From: [Arden Thomas](#)
To: [Kelly Bacon \(CD\)](#)
Subject: RE: SX-20-00002 Anderson
Date: Friday, February 14, 2020 4:18:16 PM
Attachments: [RE Anderson .msg](#)

Below is the link for the Anderson Shoreline Exemption Permit for your review and comments.

SITE PLAN

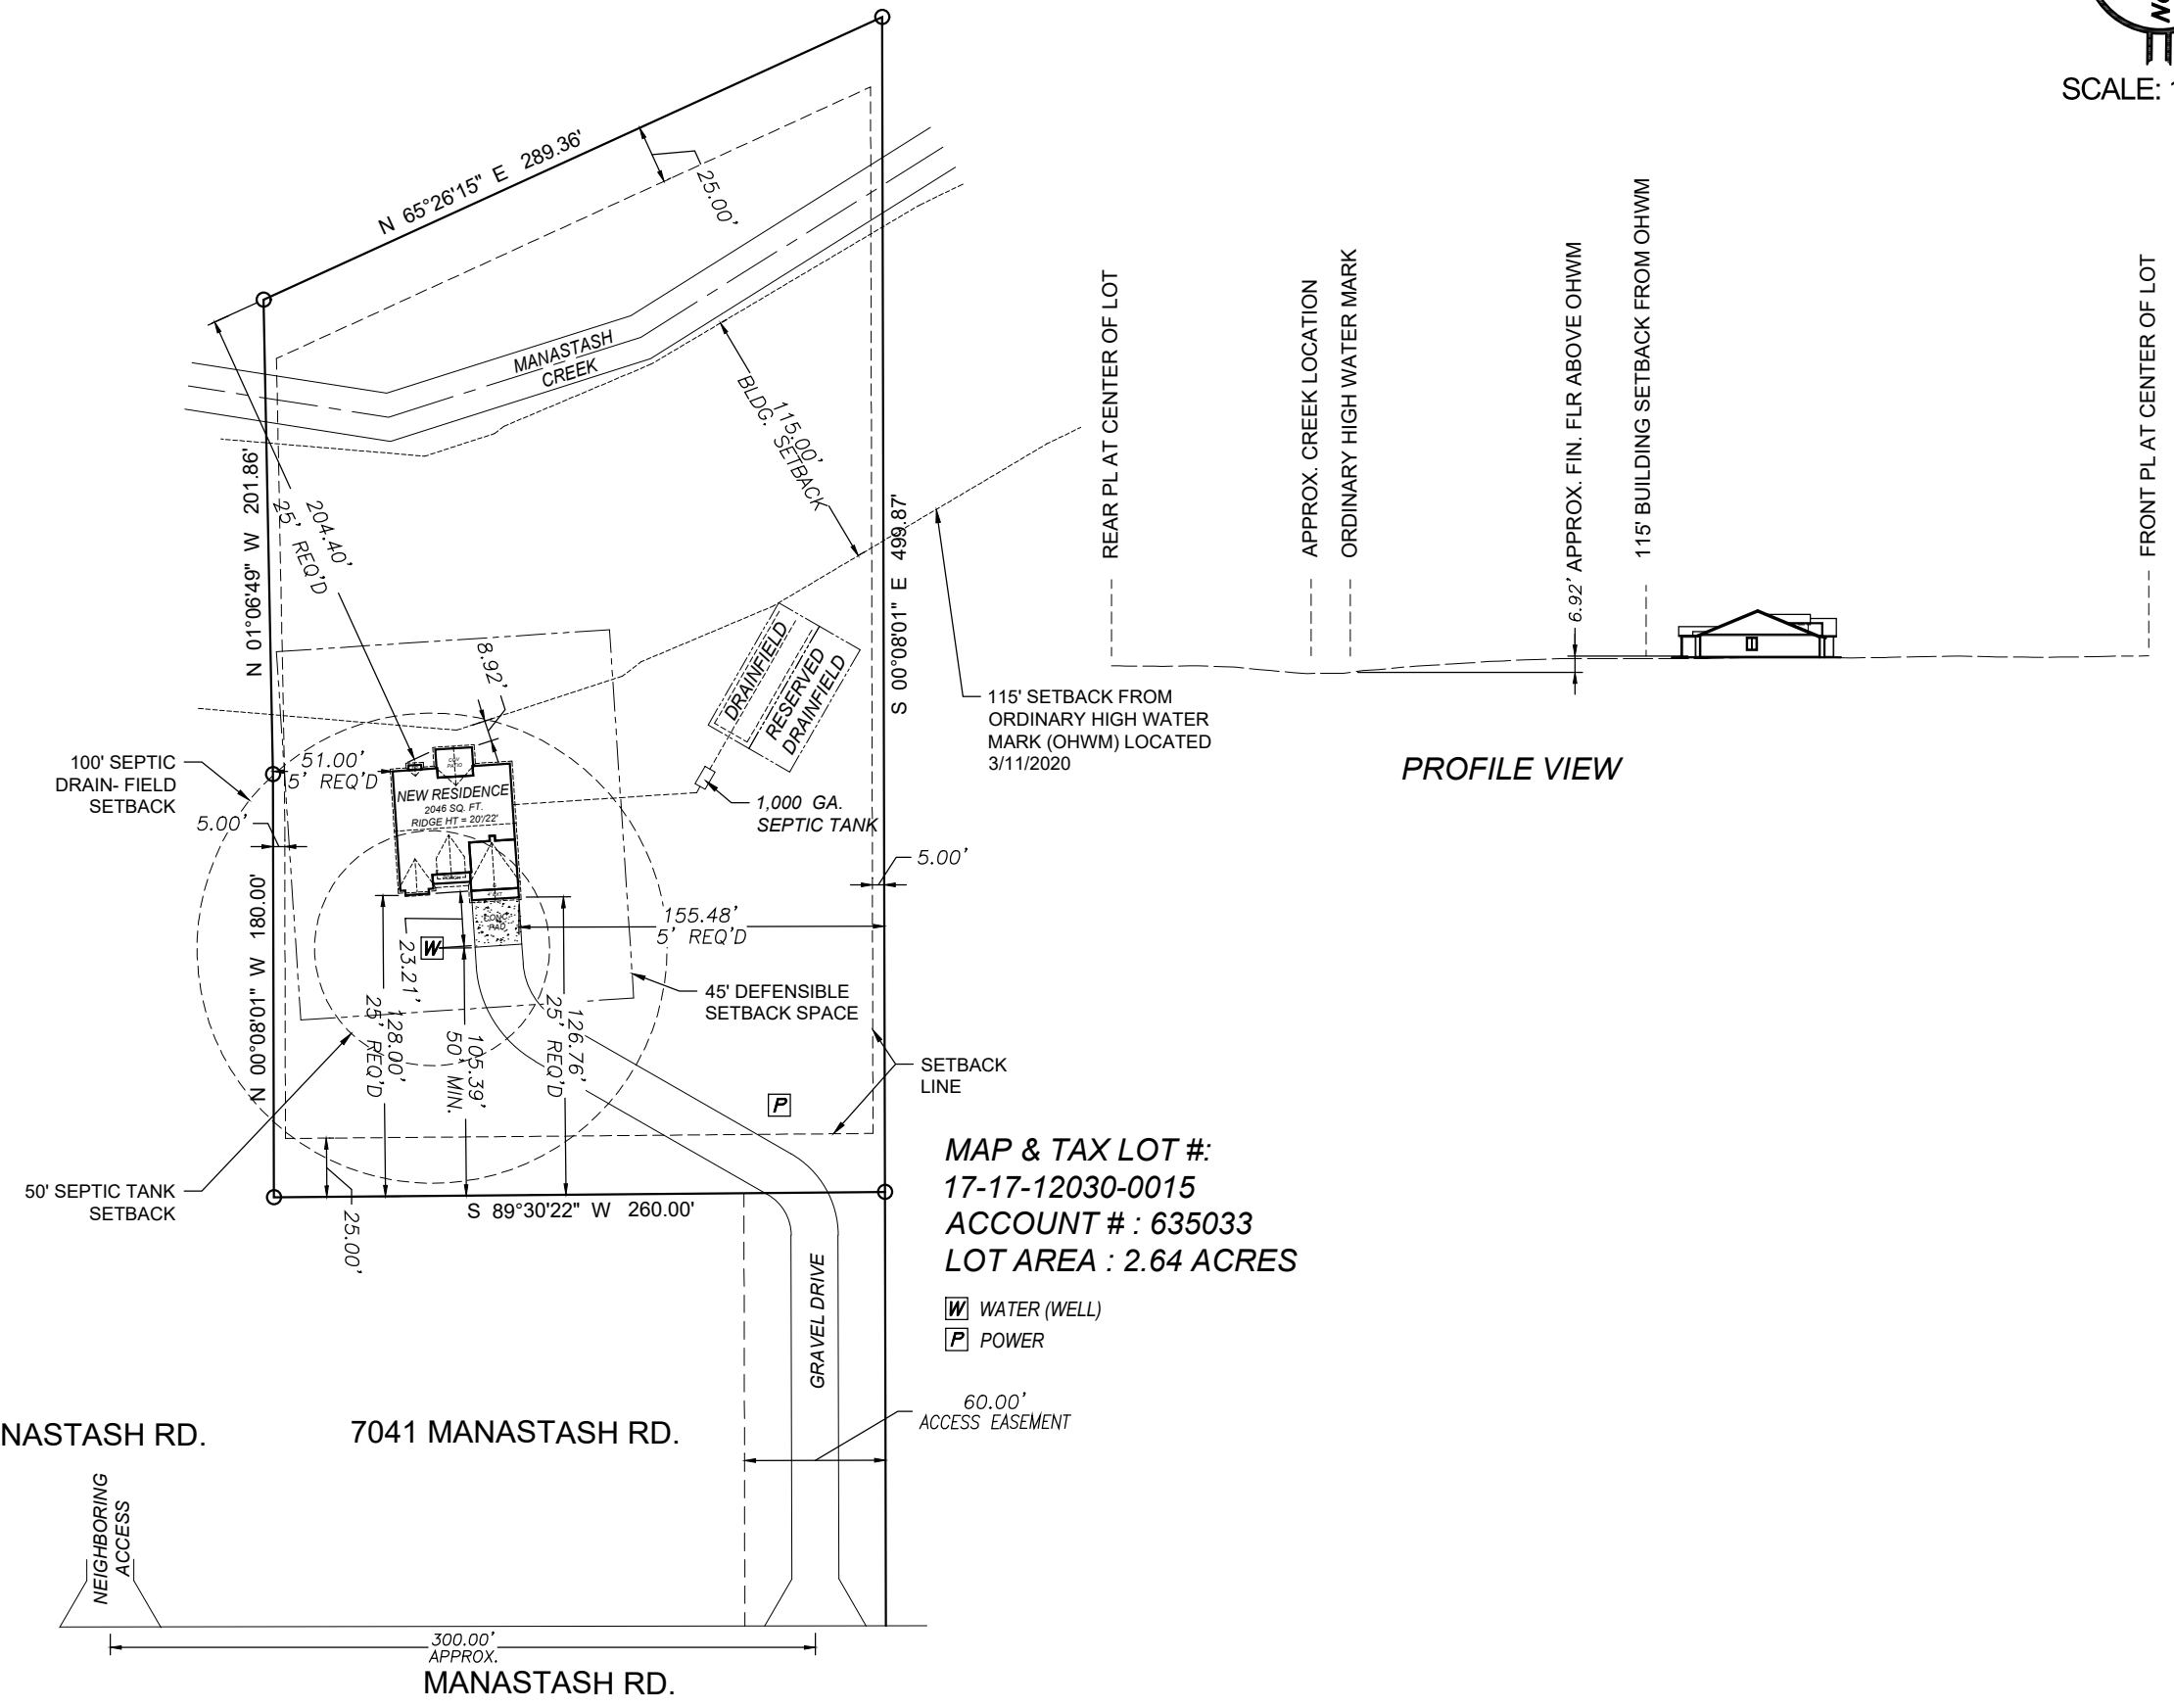
I would like an in-person meeting with the applicant to discuss the site plan and flooding risks. The house site is outside the special flood hazard area for the effective maps. However, once FEMA adopts new maps, it will be within the regulatory floodplain. I want to make sure the applicant is aware of the implications for their home and opportunities to build so that the house will be compliant when the new maps are adopted.
